EAST CAMBRIDGESHIRE DISTRICT COUNCIL

Response to Cambridge Waste Water Treatment Plant Relocation Project

The Grange
Nutholt Lane
Ely
Cambridgeshire
CB7 4EE

Planning Inspectorate Ref: WW010003
Planning Authority Ref: CWWTPRP
Date: November 2023

View from Ely Cathedral (off map)

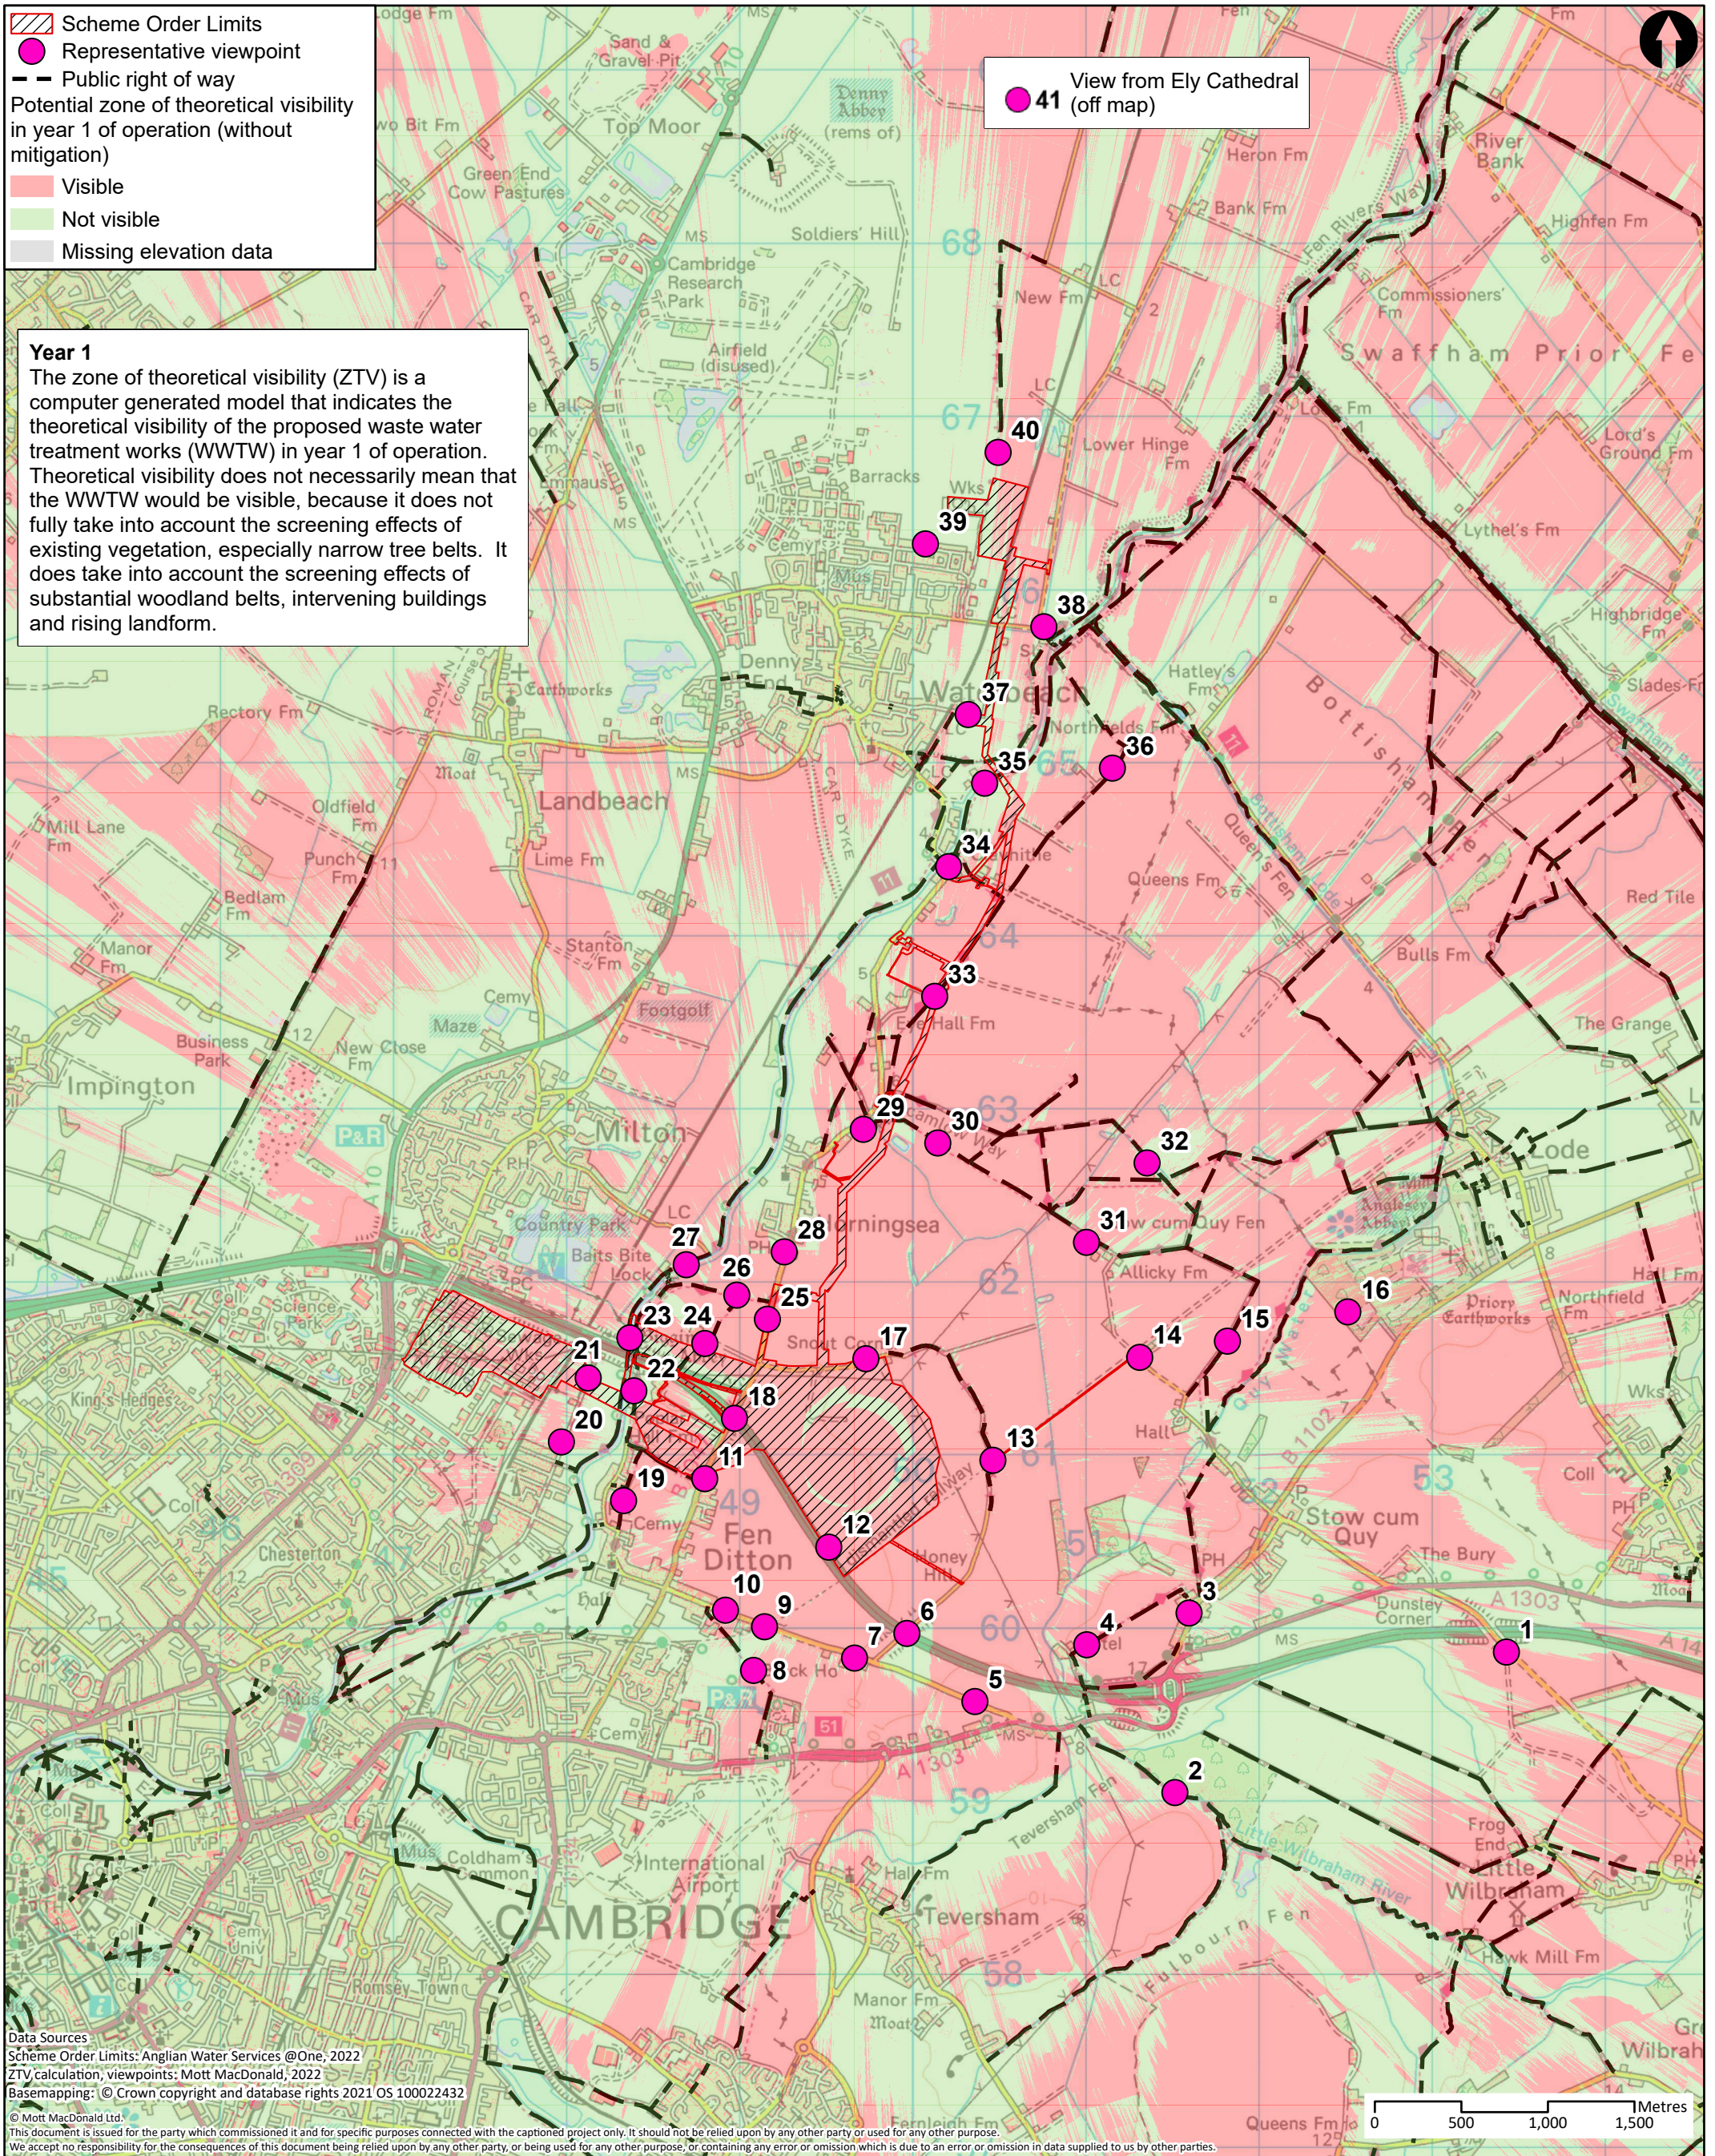
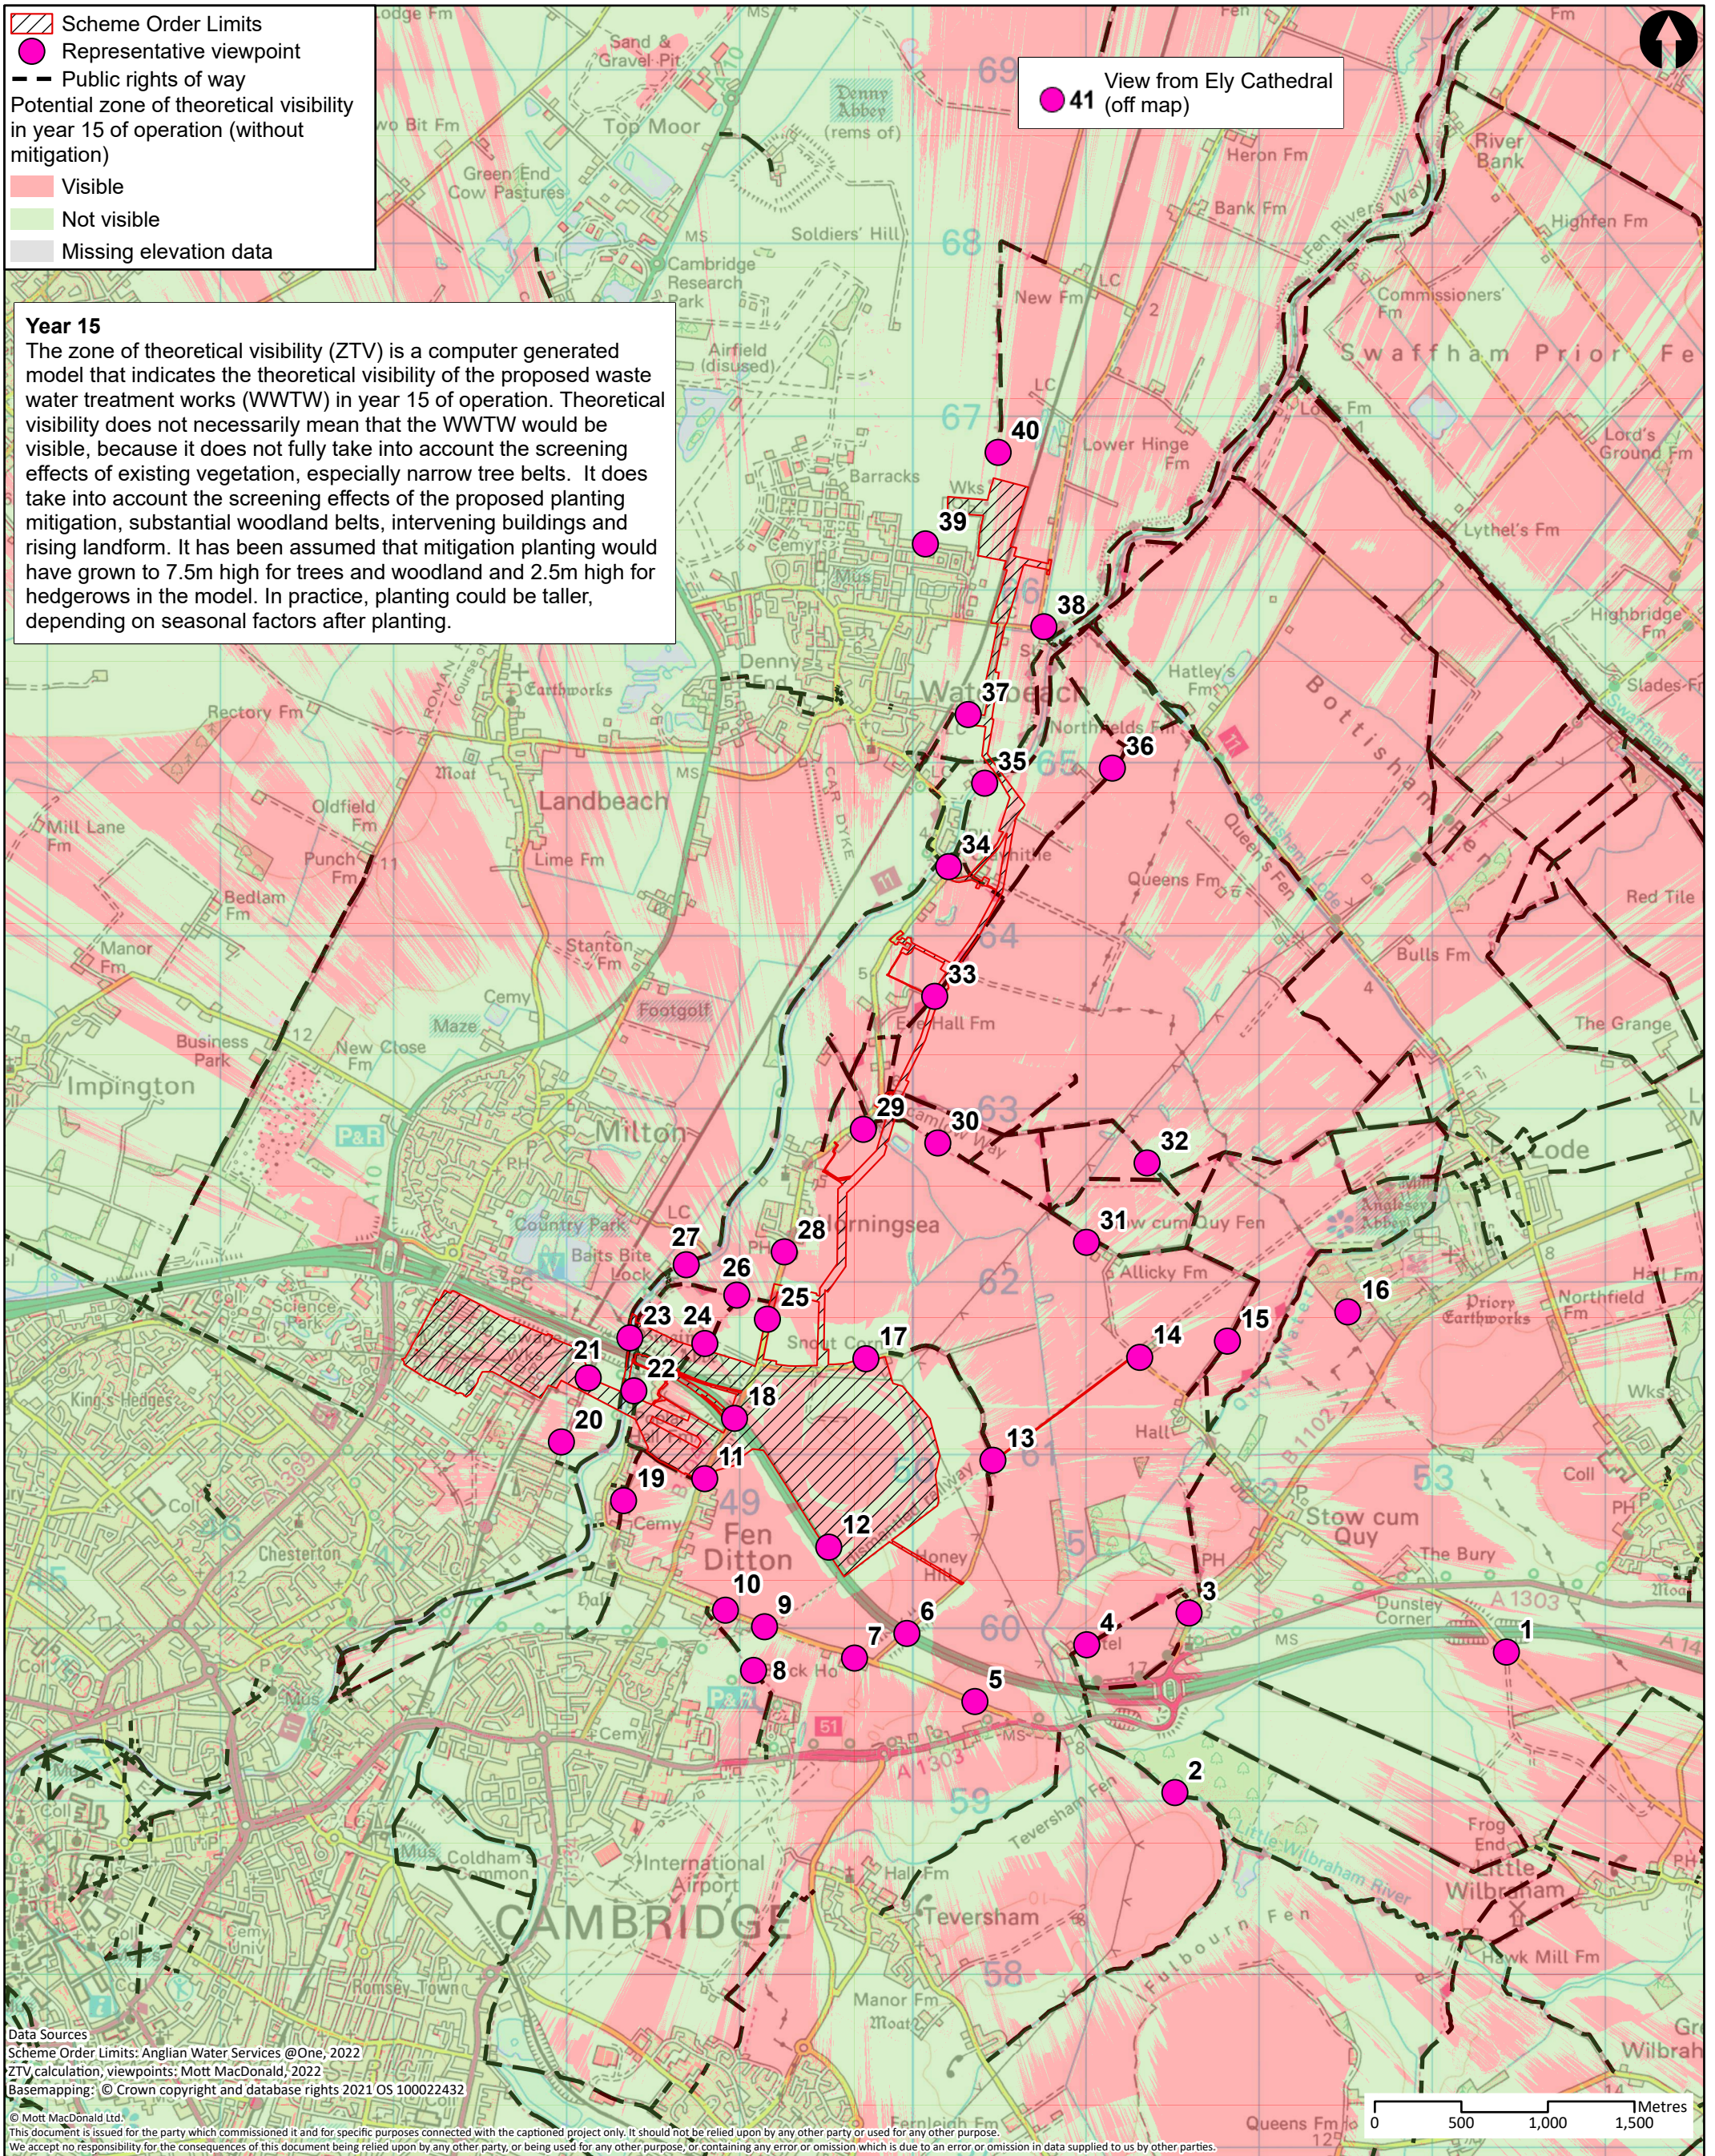
- 3.10 The viewpoint from Ely Cathedral, shows that it is possible to see Cambridge in the distance, but not possible to identify any features. Whilst there is a significant distance between the sites, Ely Cathedral's setting as a Grade I Listed Building is an important consideration. This will need to be weighed against the public benefits.
